AUSTRALIAN RAIL TRACK CORPORATION LTD

15 March 2013

**RE: CRAWFORDS AMMONIUM NITRATE STORAGE AND DISTRIBUTION FACILITY,
SANDGATE (SSD-5119)**

Figure 7: Individual Fatality Risk Criteria Contours for the Proposed Development

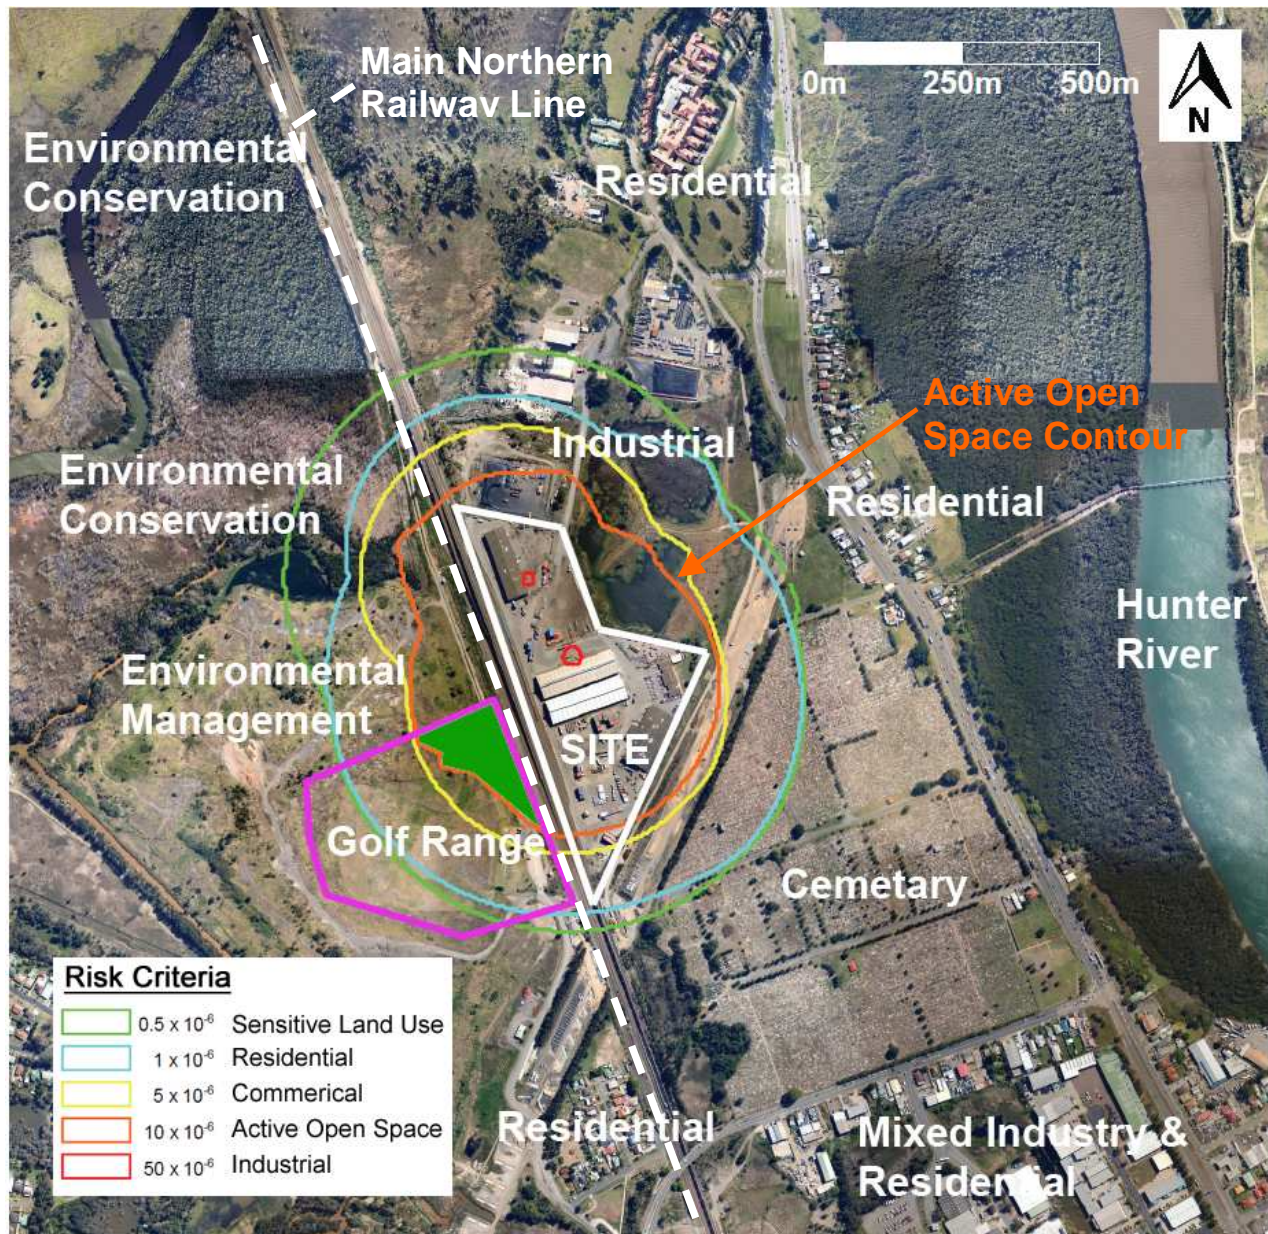
The proposed exclusion zone currently affects the railway corridor. This could shut down all operations and services on the Main Northern Railway. It is requested that the proponent investigate and provide appropriate mitigation measures to reduce the exclusion zone, to ensure that the Main Northern Railway cannot be adversely impacted.
